Town & Country Planning Act 1990 (as amended)
Town and Country Planning (Development Management Procedure) (England) Order 2015
Approval of matters reserved by condition imposed under BE/18/17/PL relating to conditions 4-archaeological works, 5-surface water drainage, 9-landscape scheme, 10-protection of existing trees/bushes/shrubs, 14-foul drainage, 15-ecological enhancement scheme, 17-landscape management plan, 18-details of laying out timetable for provisions & future maintenance of Public Open spaces, 20-10% decentralised & renewable or low carbon energy sources, 21-street lighting scheme, 23-vehicle access, 25-car parking spaces, 27-construction of road(s), footways & casual parking areas & 28-Travel Plan statement.
Land West of New Barn Lane Bersted,,

Arun District Council have decided to **REFUSE details reserved by condition for the following reasons:**

The application to discharge Condition 5 imposed under reference BE/18/17/PL is refused by virtue of insufficient detail. The following detail is absent from the submission and should be incorporated as part of any future application to discharge this condition:

Ditch Section A-A
Horiz. 1:100
Vert. 1:100

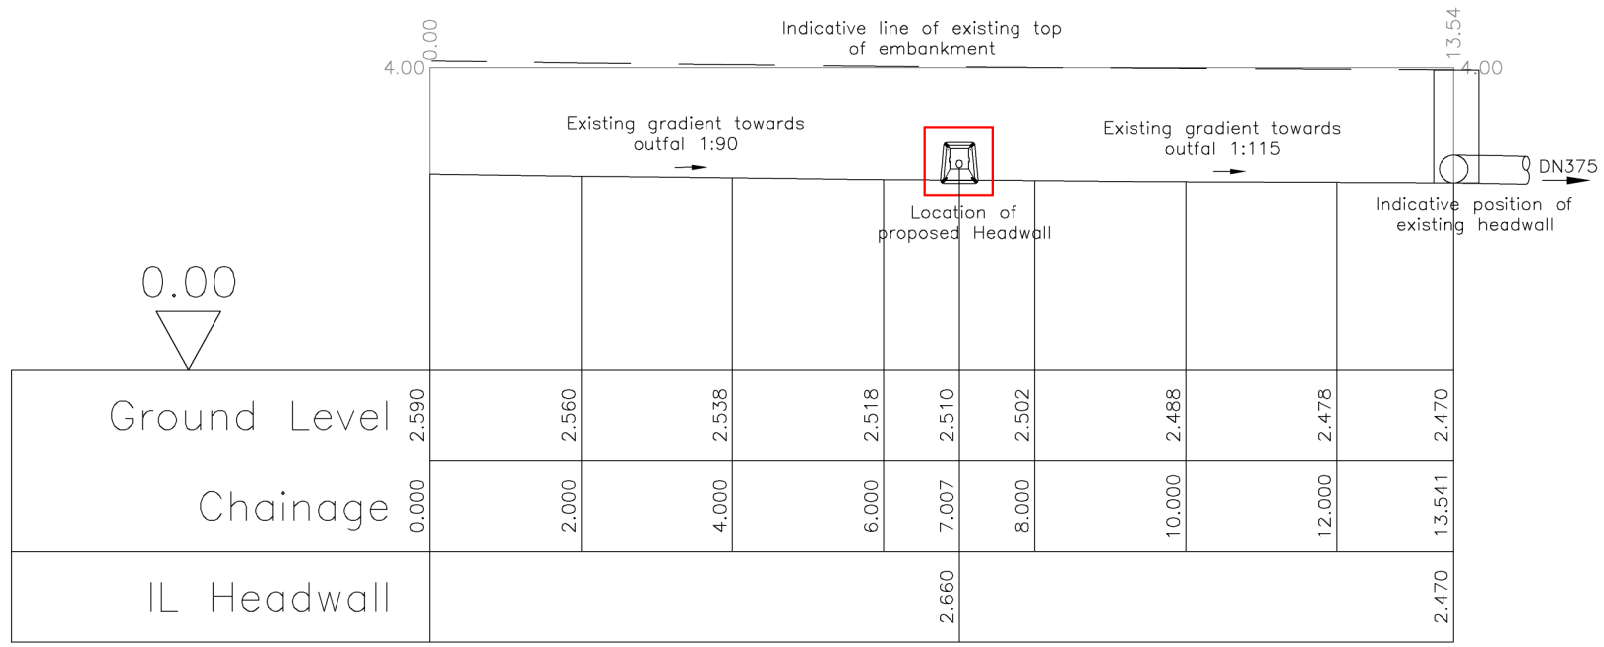
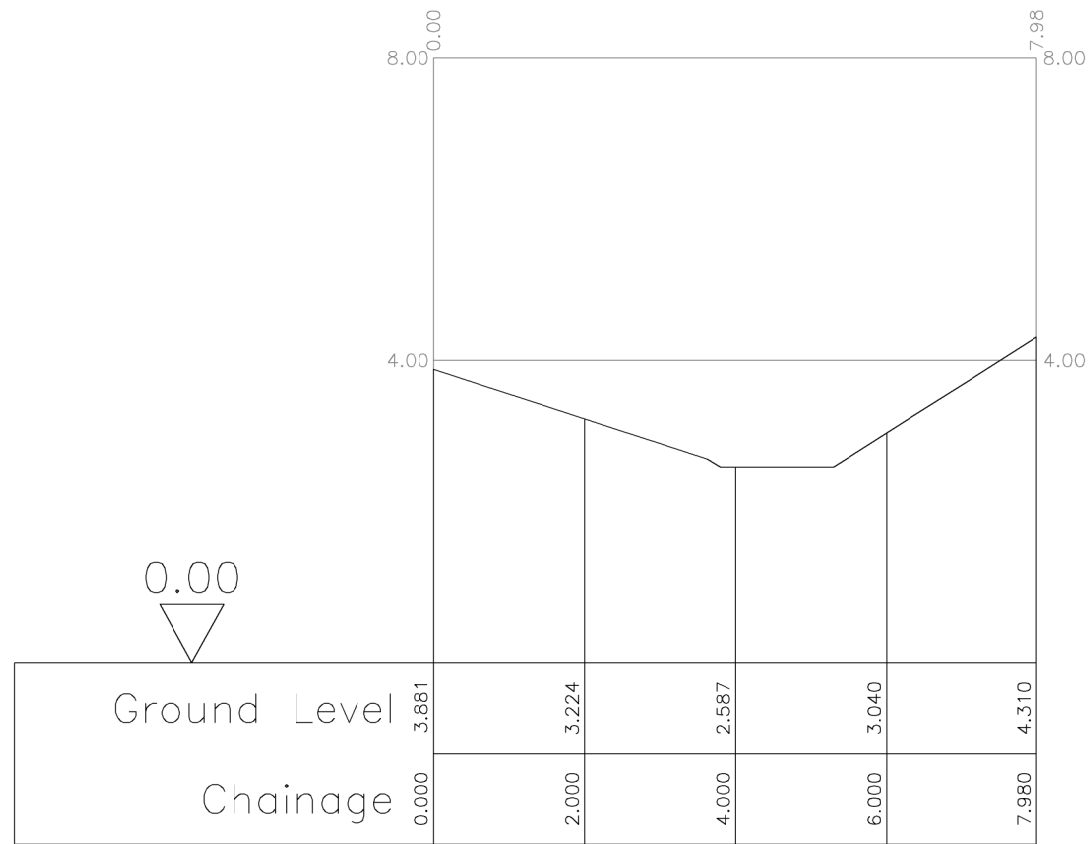
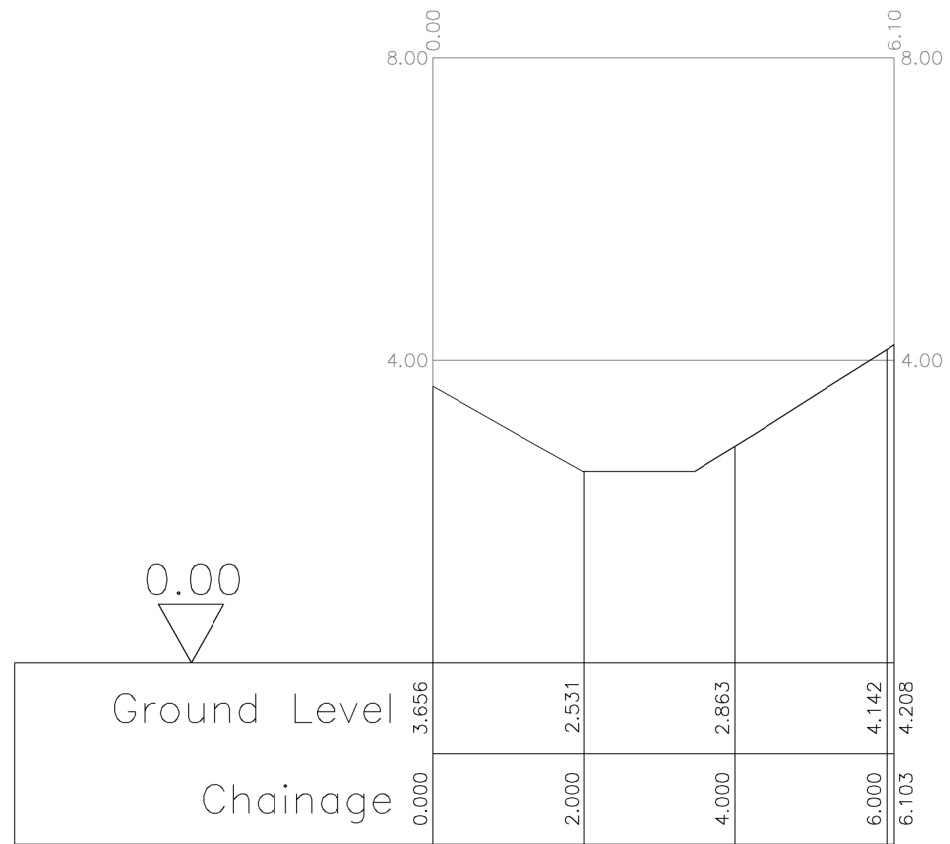
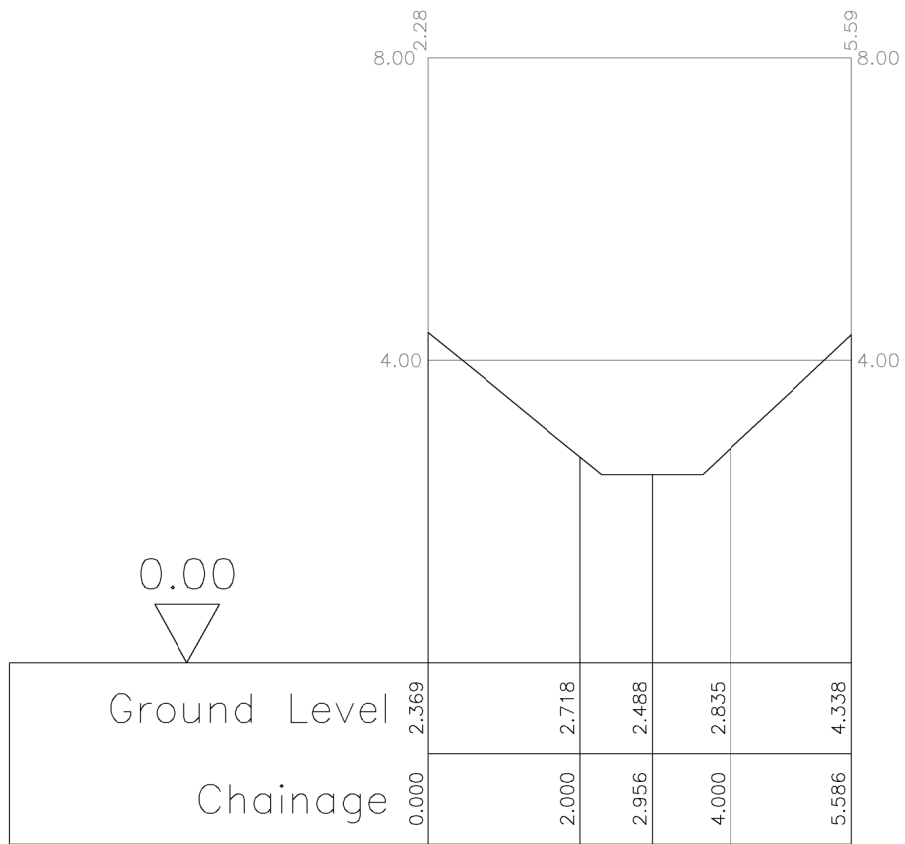
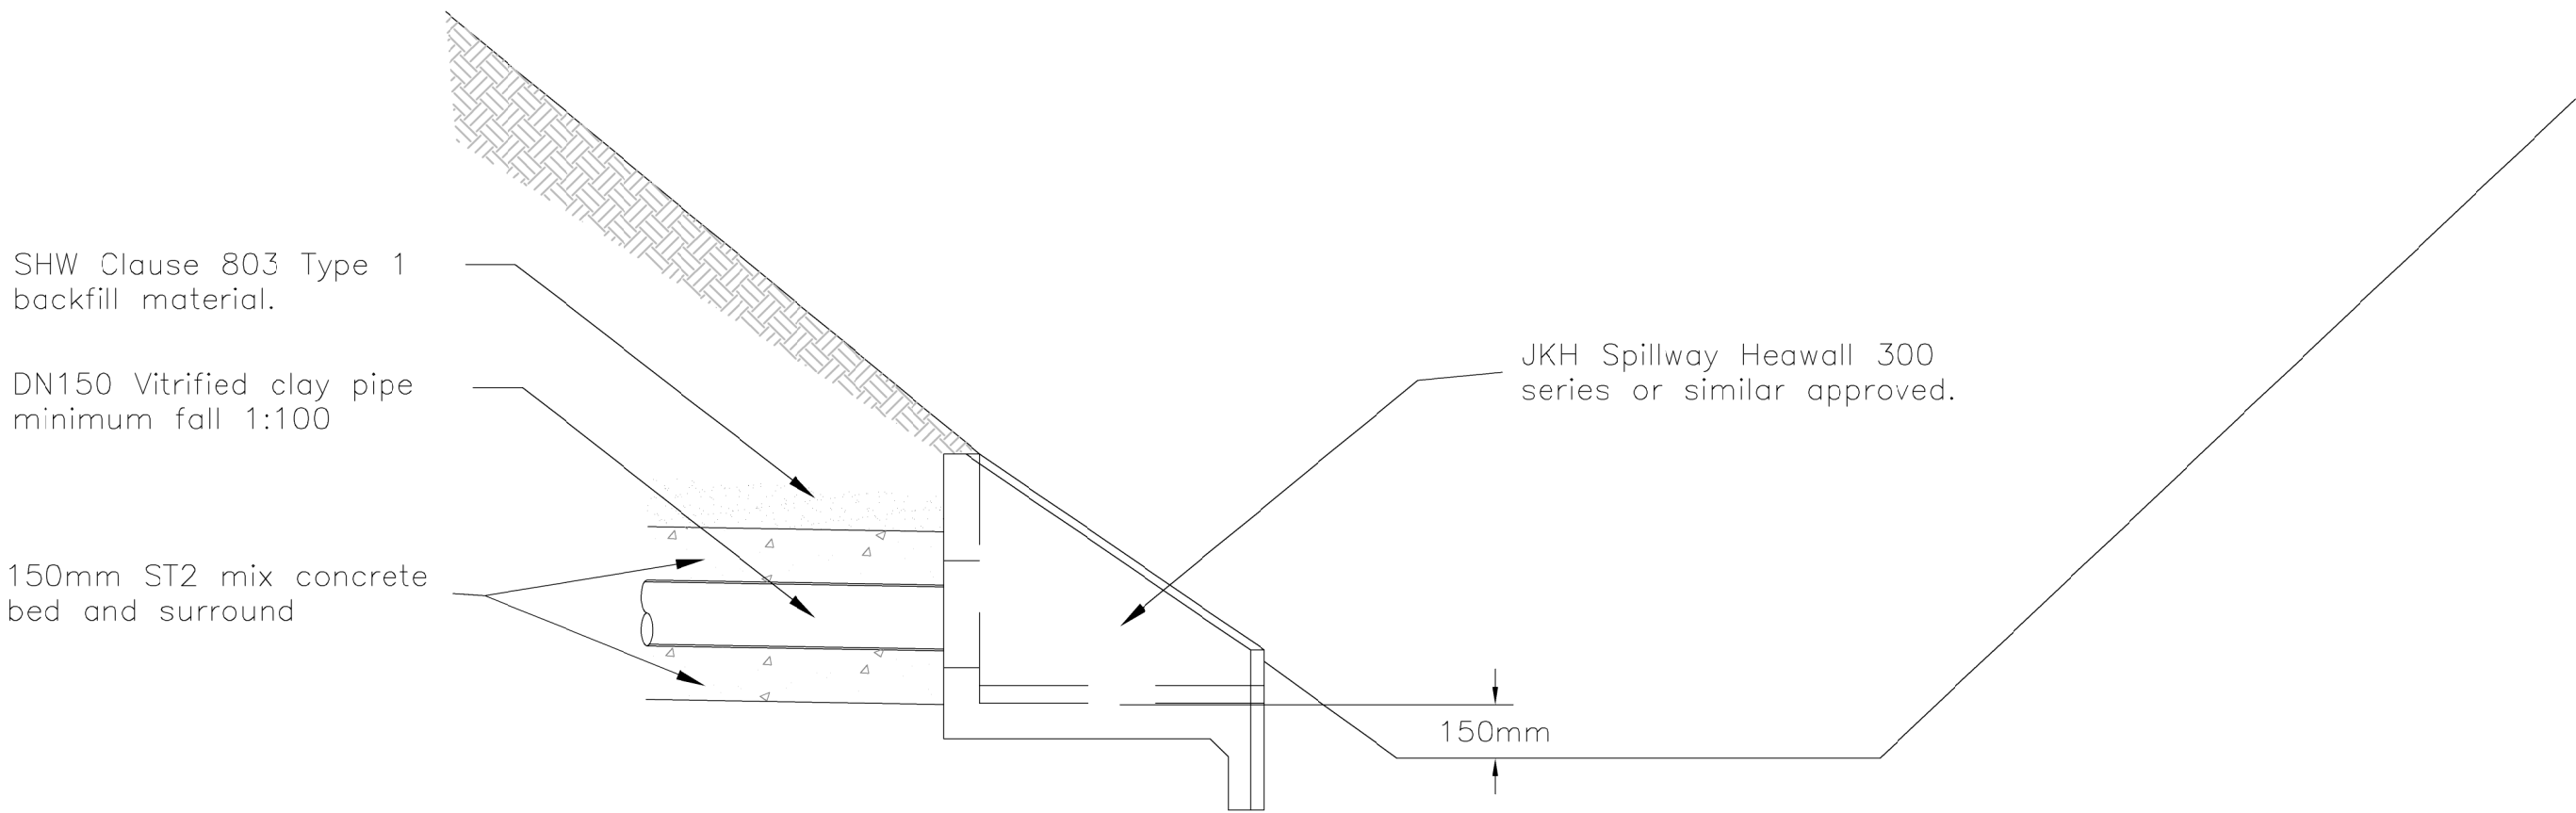
- Shallow ditch details still need to be included on the drawings, i.e. investigation required, outfall will be required if not present and ditches to be cleared out.
